Hearing Transcript

Project:	A46 Newark Bypass
Hearing:	Issue Specific Hearing 4 (ISH4) - Session 2
Date:	05 December 2024

**Viewpoint 25: View south from Great North Road (A616) representative of views for road users**

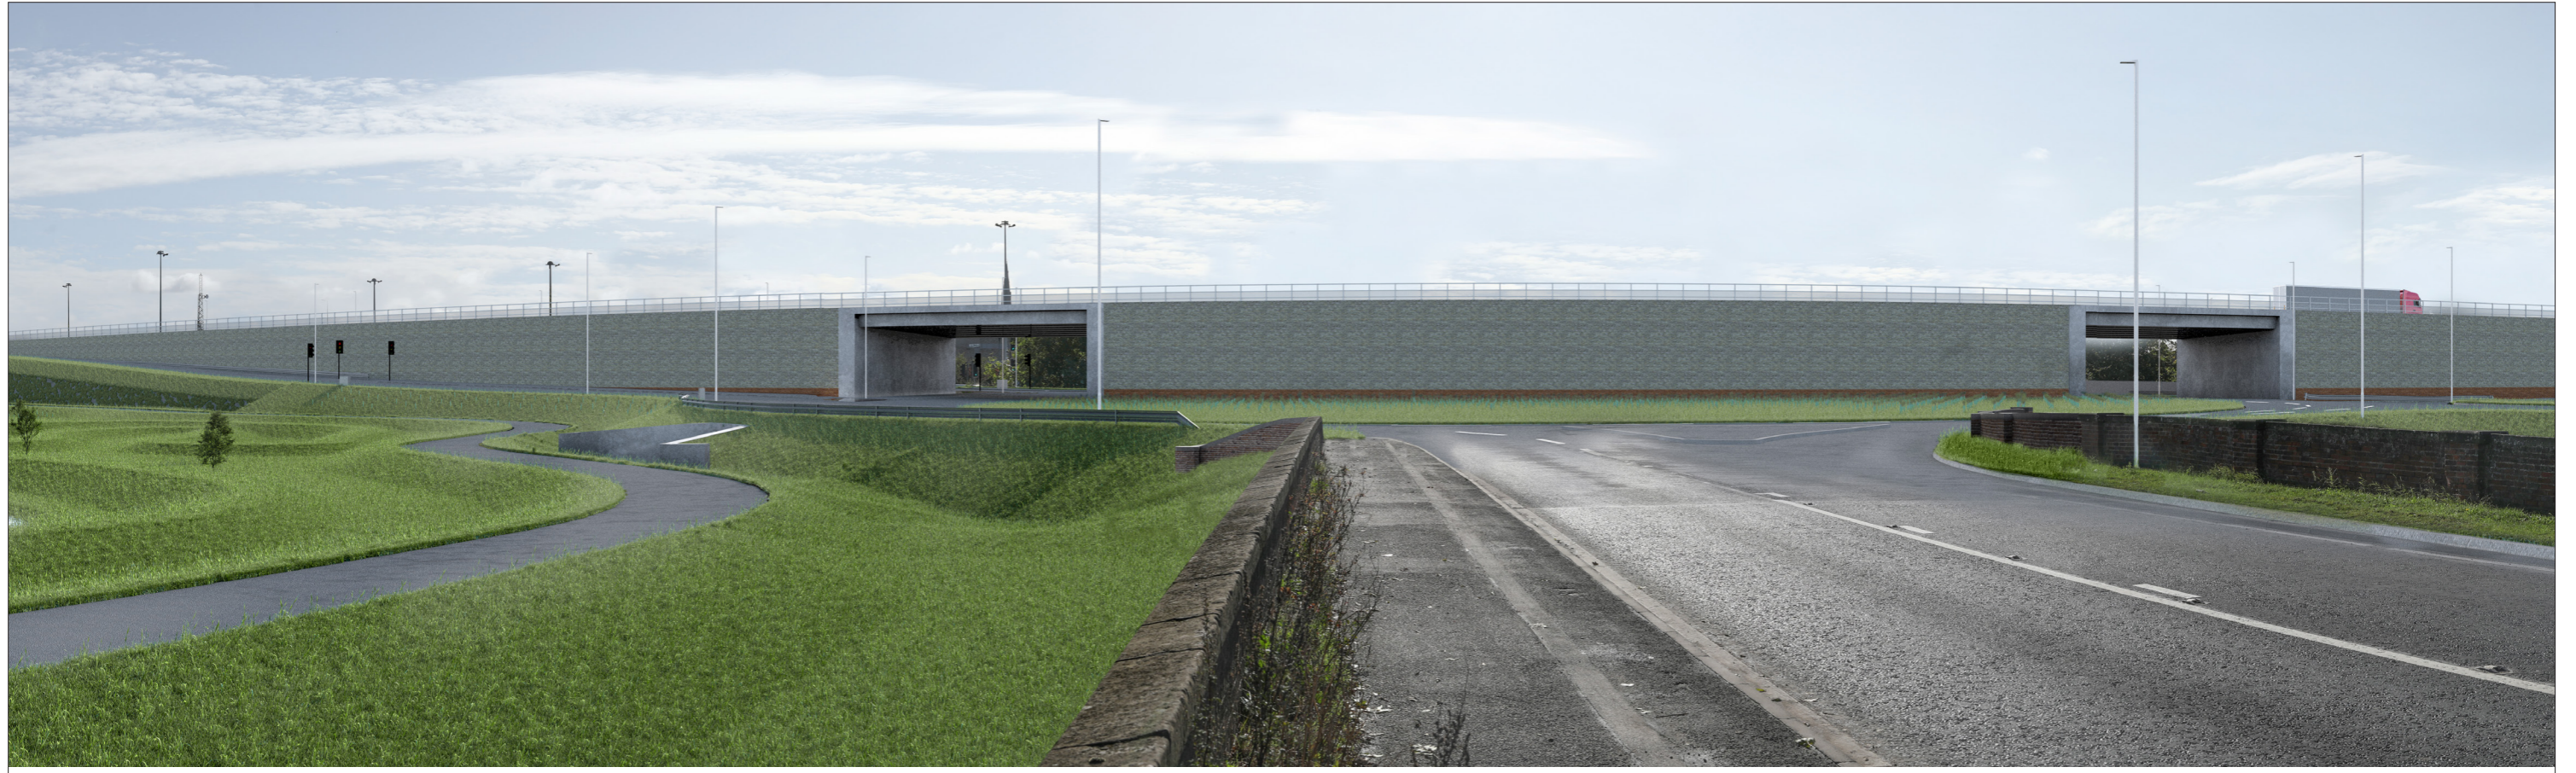
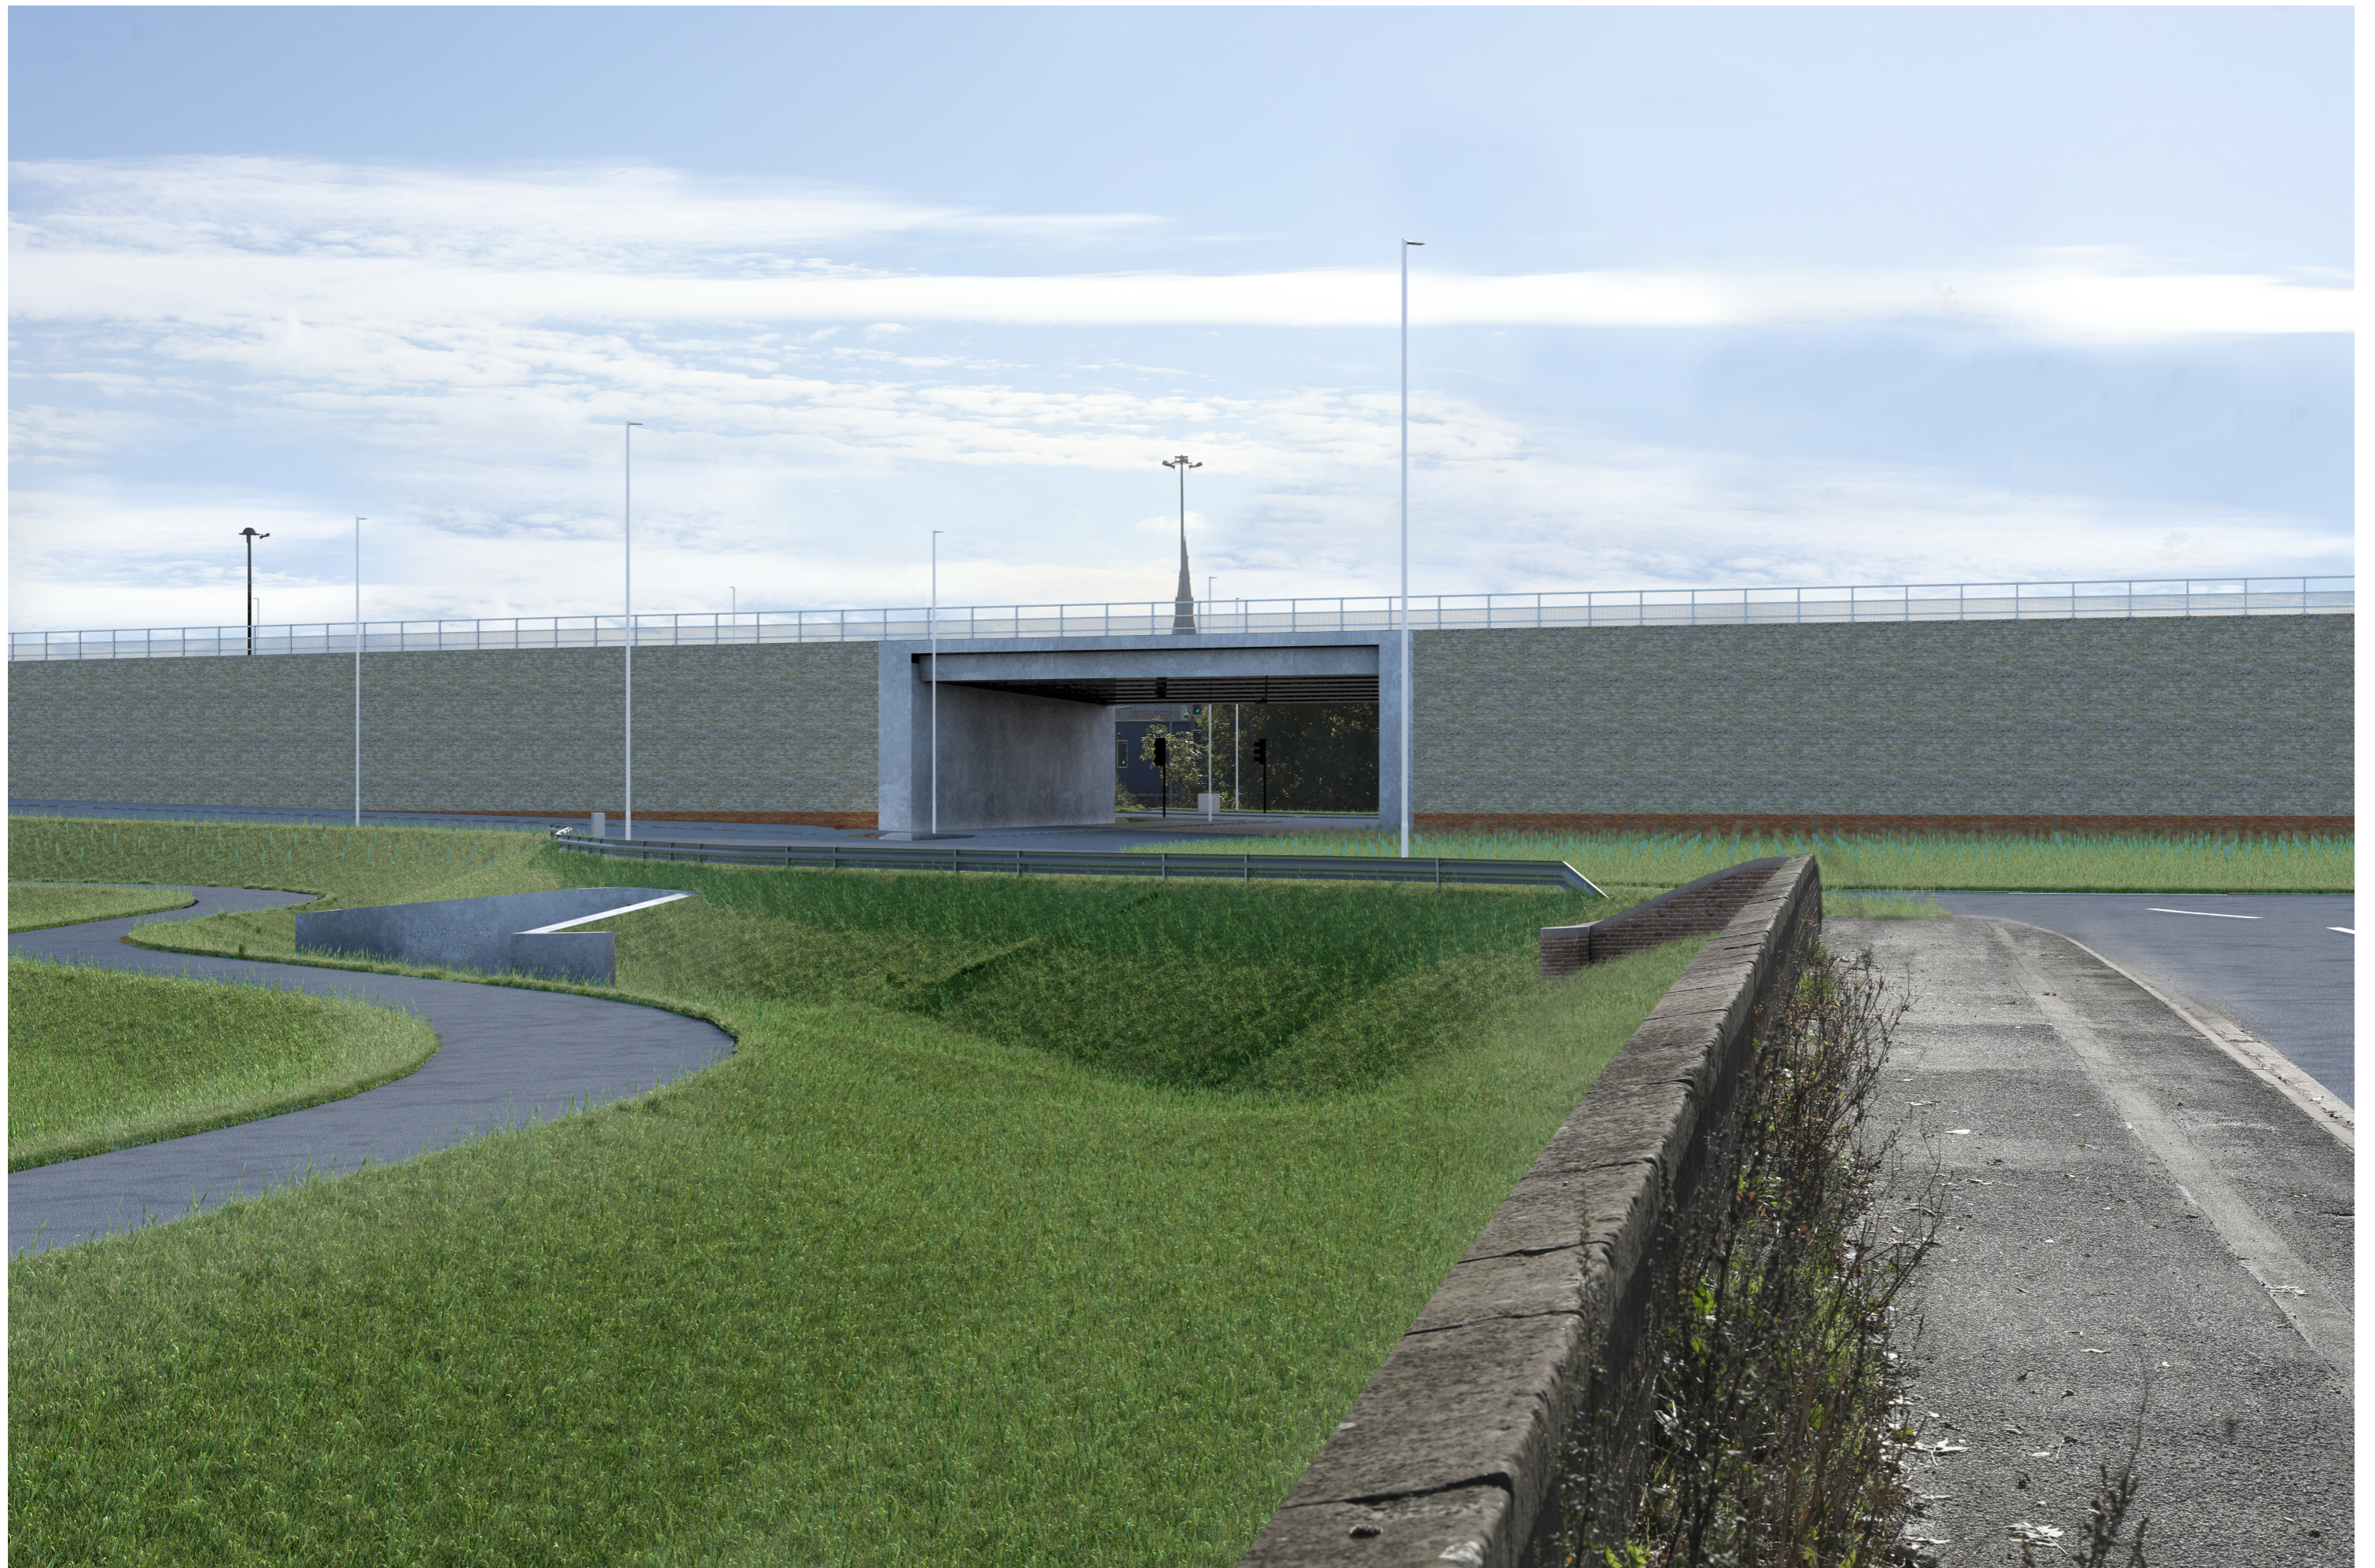
and rep two, five and 020, but both are relevant in terms of the impact they're going To view point 25 the existing situation shows vegetation as you're approaching on the A 616, towards Newark, south east, with existing vegetation on both sides of the road, framing the view down to the upgrade existing junction, and looking at year one that vegetation has been removed. So you see this full expanse of the grade separated junction and retaining wall with the framing vegetation having been removed at year

25 there's not a huge difference in terms of vegetation either side of the A, 616, and still this same horizontal expanse of the retaining wall and the elevated structure.

Alison Stewart for Newark, and show a district council it is. It relates to the loss of the boundary vegetation either side of the A, 616, as you're approaching Newark, you've got the new elevated carriageway along the full view, and because we've lost the framing vegetation that was there on the existing situation, it's a much more open view, and our concerns are that there is no proposals at the moment for any planting in that area. And was just wondering why there wasn't more thought to how this could be mitigated against this impact of this new structure on the approach into Newark.

yes, I think obviously we are raising concerns of those views into the town and out of the town. And I think that certainly views into the town could be kind of softened with a lighter structure, and we feel that it hasn't really been justified or kind of reasoned out why this is the design that's been put in front of us today, and why other options that perhaps are lighter weight haven't been brought forward to this stage.

Clay, you've done for the applicant? I think it's worth noting, when looking at this photo montage that actually there's an a line of existing vegetation that will be retained, which is immediately, essentially behind the photographer in this location. And therefore anything north of this we feel still will allow the containment of roadside views in a similar way to as it currently does, albeit understanding where there are breaks in that existing vegetation, then oblique views may be afforded across the surrounding landscape to the a 46 and the grade separated junction,

Yes. So, as we noted earlier, the swells in this location have a highways drainage function. The reason we have chosen them is for the aspects around nature based solutions, moving away from kind of the historic hard features that we might see to enable co benefits in terms of biodiversity and landscape integration. We've made an allowance for, I appreciate those can't see the environmental master plan currently, but we have made an allowance for individual trees and, again, some shrub planting adjacent to the retaining walls as you head left around the junction. In addition to that, we've also obviously got the planting on the junction itself. In the image that we looked at in year one, see they're very small in that location at that time. However, by year 15, they will have established to aid the screening of the junction, particularly at the lower levels, where the lower band of the retaining structure would be screened by that intervening vegetation, with the individual trees creating a greater aspect of height, which, in turn, can help break up the upper, upper sections of that wall. Okay,

Claire Eden for the applicant. So as a I think this is a general rule that we can talk about across the scheme. And our approach is that we've sought to maximize the retention of existing vegetation where we can and also maximize the planting, as you'll see on this on the screen here, we do have a number of constraints associated with the with the drainage of the of the scheme, but in doing so, have chosen this solution because we feel that it gives a more naturalistic approach to draining the scheme,

as opposed to hard features. We have produced some patrose, some planting along that boundary, albeit we do have to be mindful of planting offsets from carriageways in order to align with industry standard guidance around the safe operation of the highway and LD 117, appreciating as well that perhaps the planting that provision that's there already may have naturalized over time and possibly not being maintained as per the highway standards in in respect to offsets from carriageway.

Thank you. John Bose, on behalf of the applicant, I'd already looked at this, and we did look at this as part of the options development, and discussed it with a number of the stakeholders. So in providing an open structure, the spans would become larger, and the overall depth of the structure would increase between 305 100 millimeters, and this would then increase the height of the structure itself, the road alignment, because we couldn't come down at this stage. And it would also reduce the safety of the slip roads, and the mergers and the departures we have there due to the increase in height the land beneath the open structure that would be hardened and wouldn't be able to be planted, creating a utilitarian environment. The area beneath the open structure would be vulnerable to anti social behavior, bitter collection and also arson risk the center of the gyratory, as shown on the existing one year and 15 year plans that would still be planted. So the open aspect would actually disappear over time, because the planting would block that view through the structure, the views of Newark castle and the church spire, in our view, at that time, and we assessed it, were already restricted by the trees and shrubs on the approach to the gyrate tree to the existing roundabout, and that those views actually came into view. And the feeling of an avenue, as I would describe it, is actually beyond the capital market roundabout. As you head down the southern side of Great North Road, in terms of the multi span structure, it would need to be placed on bearings because of its length and due to temperature changes. It allows the bridge to move. These two proposed structures are integral structures and have no bearings. If bearings are provided in a multi span structure, this would provide additional maintenance and repair requirements, increasing health and safety risks of working at height and also removing and replacing the large bearings in the structure. In terms of the final part of the consideration, we looked at the capital and whole life costs the two at the example, of just opening up the center would increase this by 6.5 million pounds. Thank you.
